**WELWYN HATFIELD BOROUGH COUNCIL
EXECUTIVE DIRECTOR - PLANNING, PUBLIC PROTECTION AND GOVERNANCE**

DELEGATED APPLICATION

Application No: 6/2019/0922/HOUSE
Location: 78 Bell Lane Brookmans Park Hatfield AL9 7AY
Proposal: Erection of a front extension to garage with a pitched roof
Officer: Mr William Myers

Recommendation: Refused

Date:	April 2019
Scale:	A1@1:100
Dwg:	76/2018 3
Drawn by:	dd

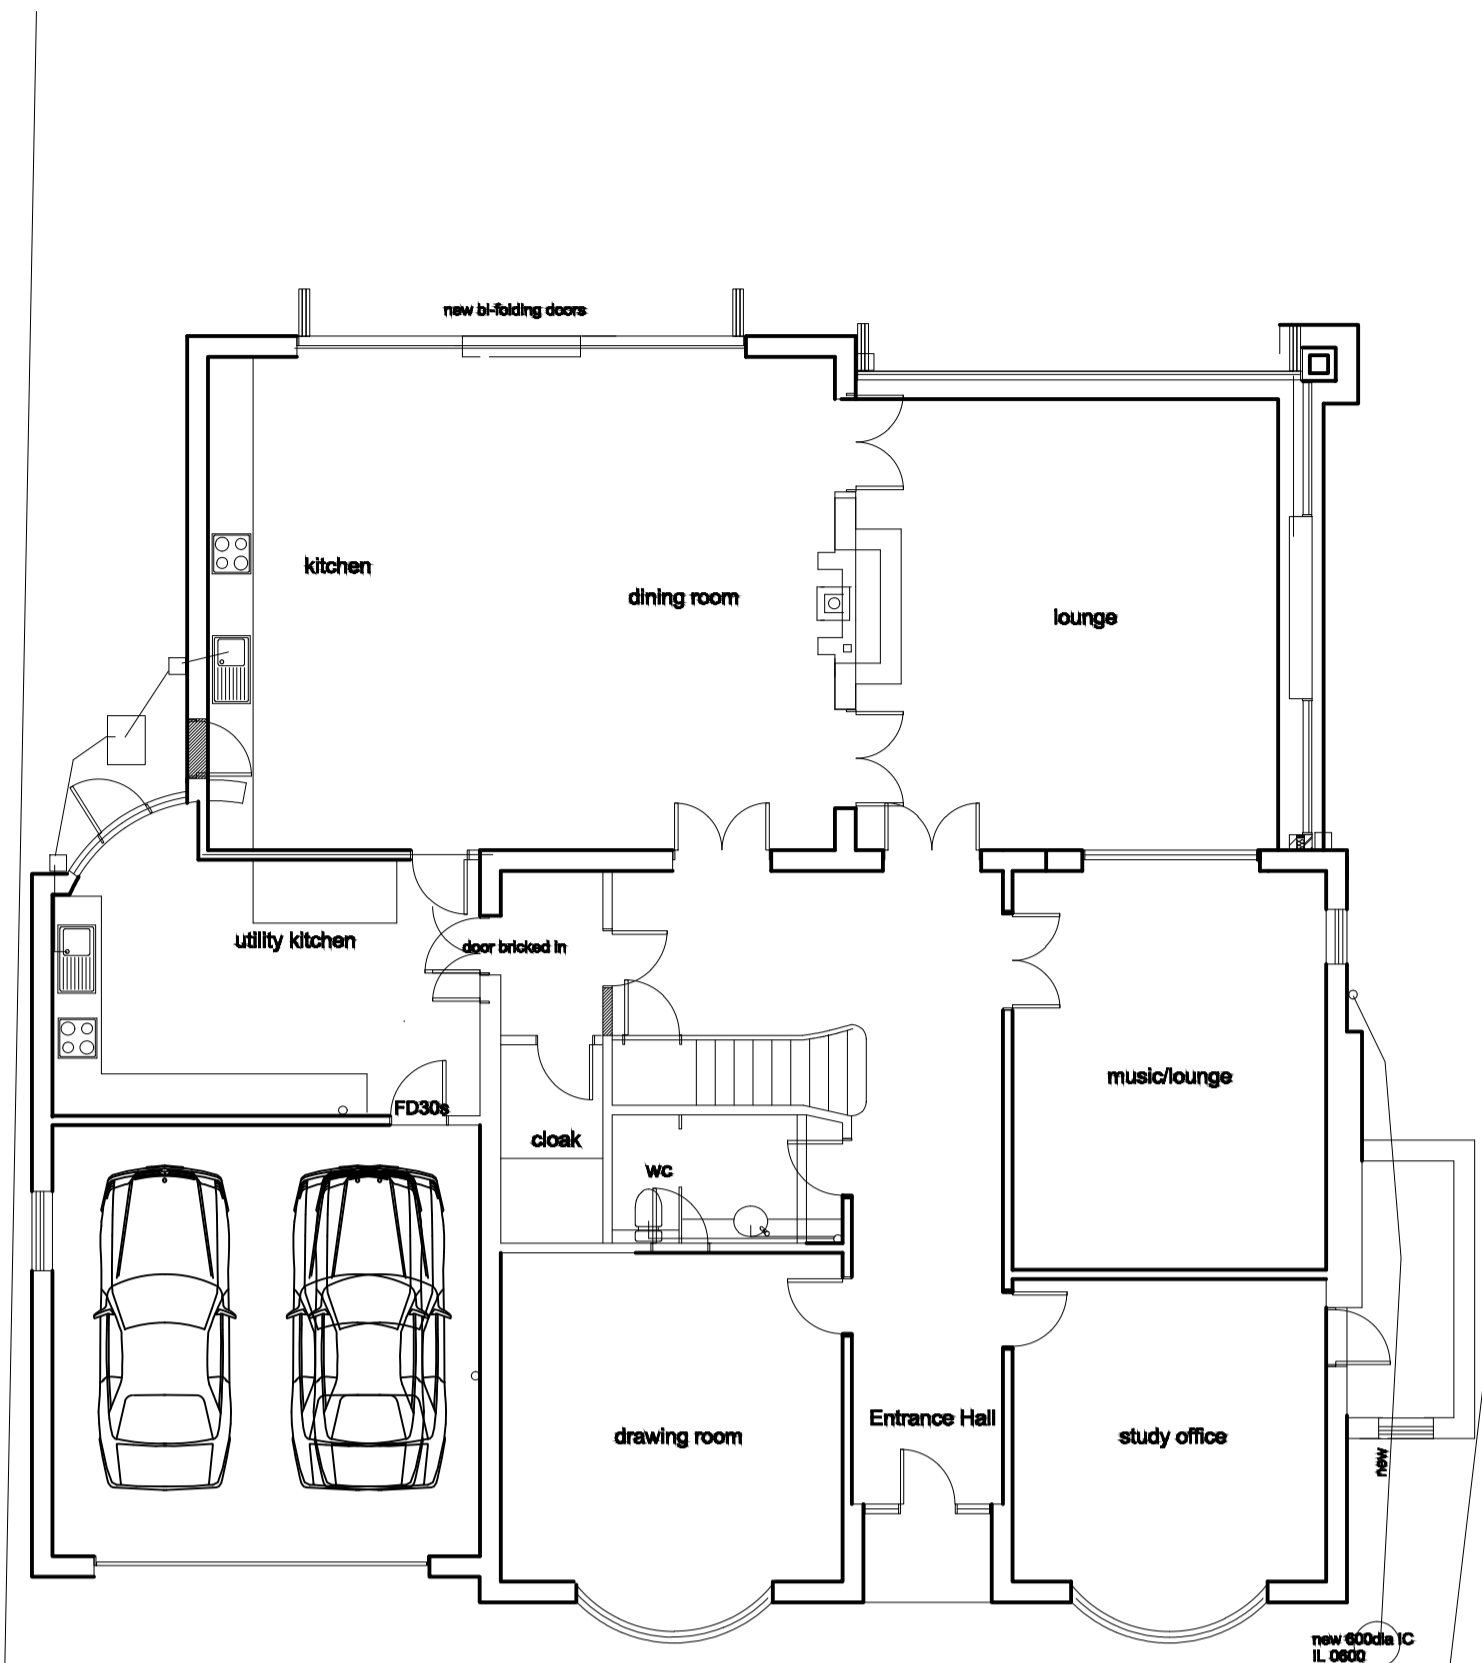
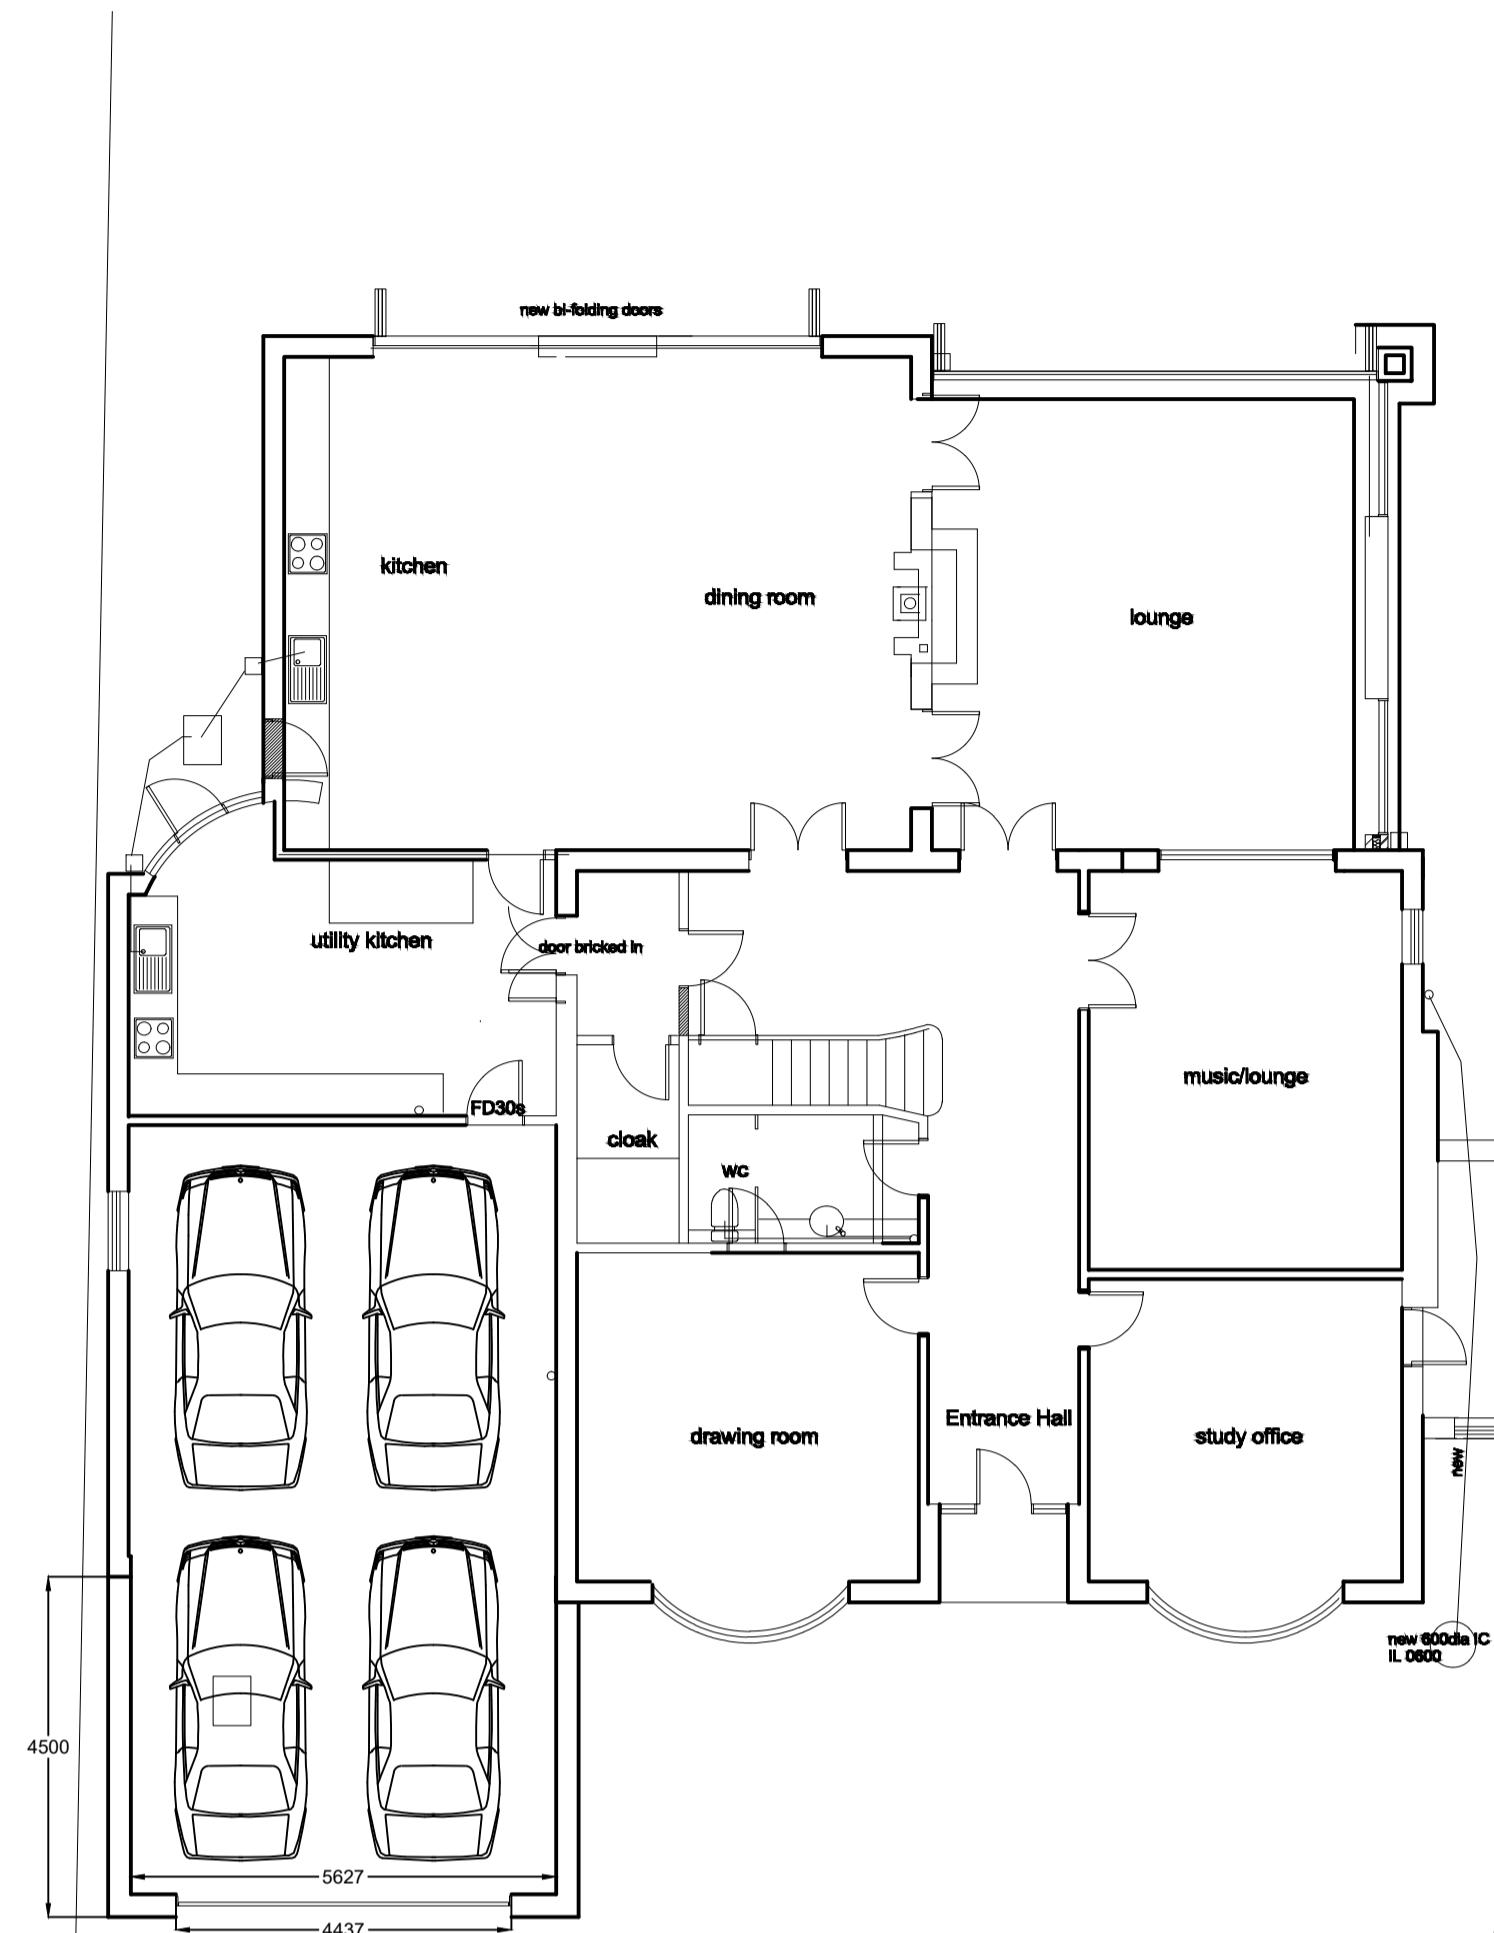
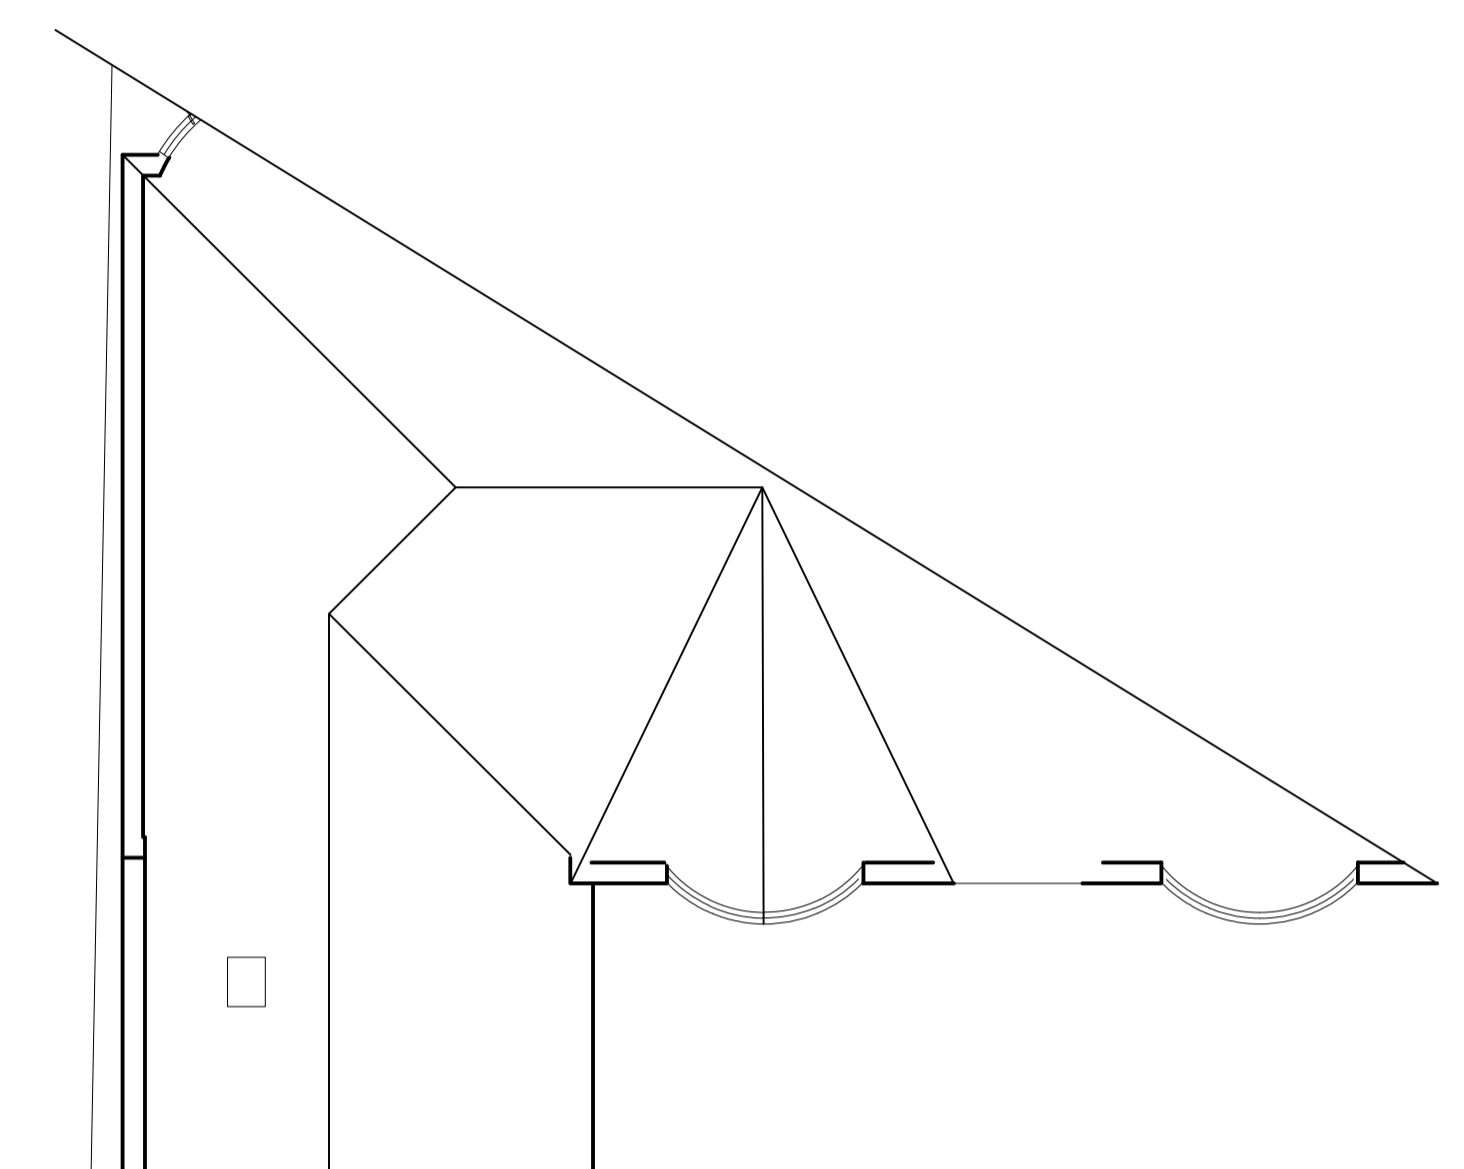
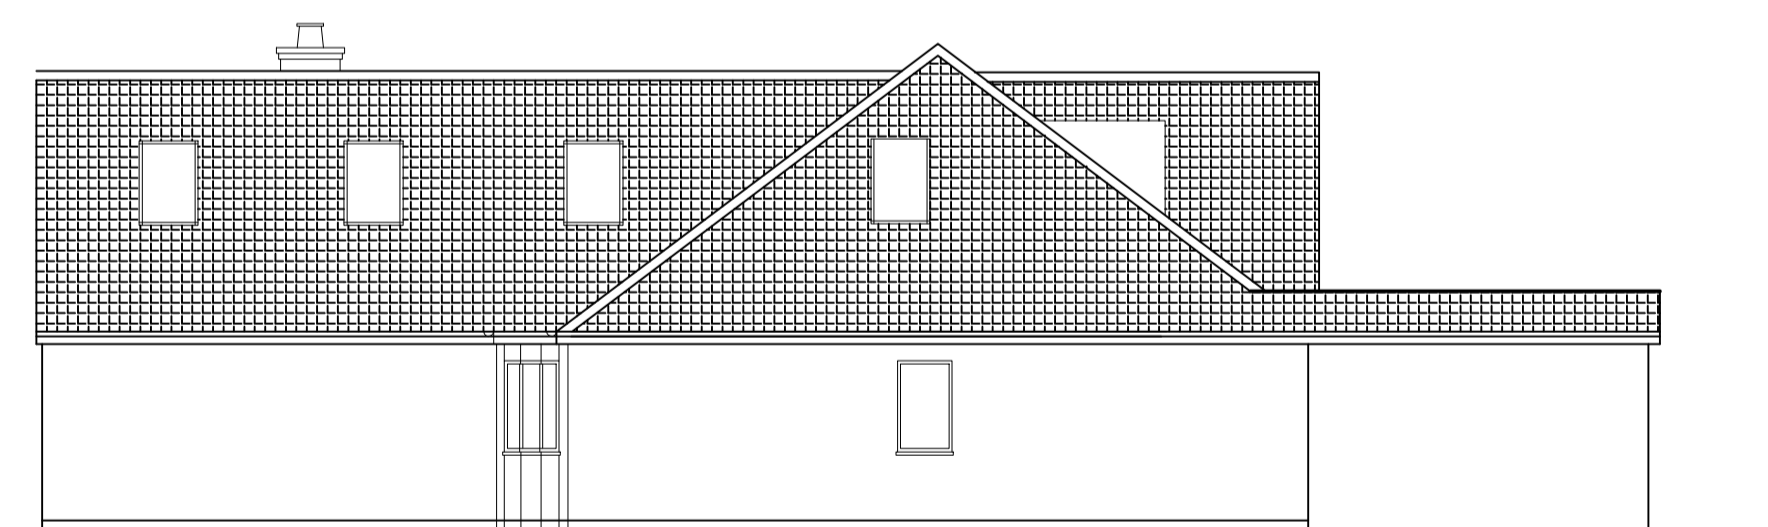
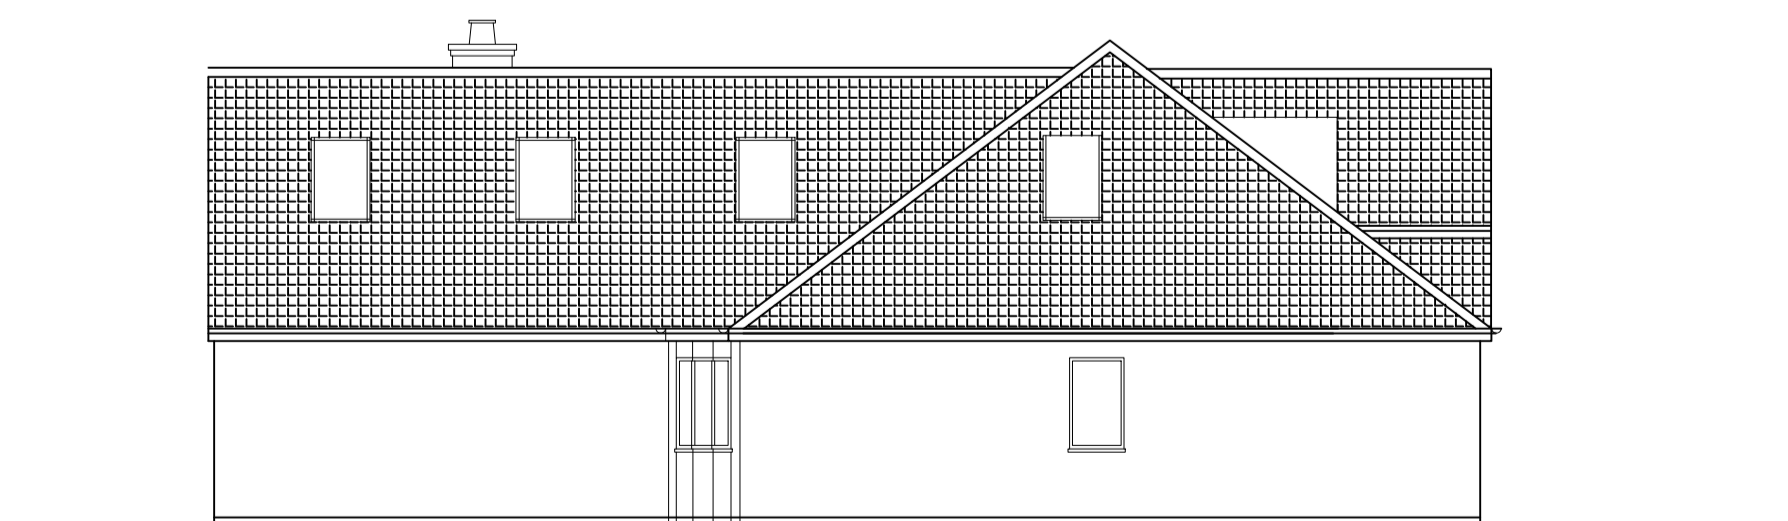
The proposed extension would result in the property being extended to its front with a single storey extension which would project approximately 4.5m beyond front elevation. The proposed development would result in the creation of approximately 24m² of new floor space. This addition, taken cumulatively with existing additions, would represent approximately 165% increase above the size of the original dwellinghouse. Although it is noted that the proposed extension would have smaller height than that previously considered, it is not judged that this would make the proposal acceptable. On a purely mathematical calculation the extensions to the original building would be disproportionate. However, in addition to mathematical calculations the visual impact of the extensions has to be considered.

Further to the above discussions about the proposed increases, it is considered that such an addition to a dwelling, which has already been significantly extended, would have a harmful impact on the openness of Green Belt. The design, character and appearance of the proposed extensions would not be consistent with the general pattern of development and character of the area. The essential characteristics of Green Belts are their openness and their permanence and the loss of openness in the Green Belt resulting from the proposed extensions would conflict with this essential characteristic. Significant weight must be attached to this loss of openness.

The proposal would add further development to an already disproportionately extended dwelling. For the reasons discussed, the proposal fails to meet the exceptions set out in paragraph 145 of the NPPF. It would, therefore, be inappropriate development in, and thus harmful to, the Green Belt. It would also conflict, with Local Plan Policy RA3 and emerging Policy SADM 34, which seek, among other things, to ensure that extensions, either alone or cumulatively with other extensions, do not result in disproportionate additions over and above the size of the original dwelling. Furthermore, the increased bulk and massing of the proposed development would result in a loss of

1. The proposed extension together with existing extensions, would result in disproportionate additions over and above the size of the original building, as such the proposal represents inappropriate development within the Green Belt. Furthermore, the increased bulk and massing of the proposed development would result in a loss of openness and visual permeability of the Green Belt. Very special circumstances do not exist to outweigh the harm to the Green Belt. Accordingly the proposal is contrary to the aims of the National Planning Policy Framework 2019, Policies GBSP1, GBSP2 and RA3 of the adopted Welwyn Hatfield District Plan 2005 and Policies SP3, SP25 and SADM34 of the Draft Local Plan Proposed Submission 2016.

2. By reason of its size, bulk and design, the extension would fail to appear subordinate or subservient in scale, resulting in an excessive and contrived addition which would fail to adequately respect, or relate, to the existing dwelling. Furthermore, the proposed extension would create a dominant feature to the front of the property which would harm the character and appearance of the host dwelling and the surrounding area. The proposal is therefore of poor quality design which fails to comply with the National Planning Policy Framework 2019, Policies D1 and D2 of the Welwyn Hatfield District Plan 2005 and the Supplementary Design Guidance 2005.

3. The proposed development, due to its scale, bulk and siting would unacceptably harm the amenity and living conditions of the occupiers of No. 80, through loss of light to habitable rooms and an overbearing presence of built form close to its boundary. Accordingly the proposal is of a poor quality design contrary to Policy D1 of the Welwyn Hatfield District Plan 2005 and would fail to accord with the Council's Supplementary Design Guidance and with the National Planning Policy Framework 2019.
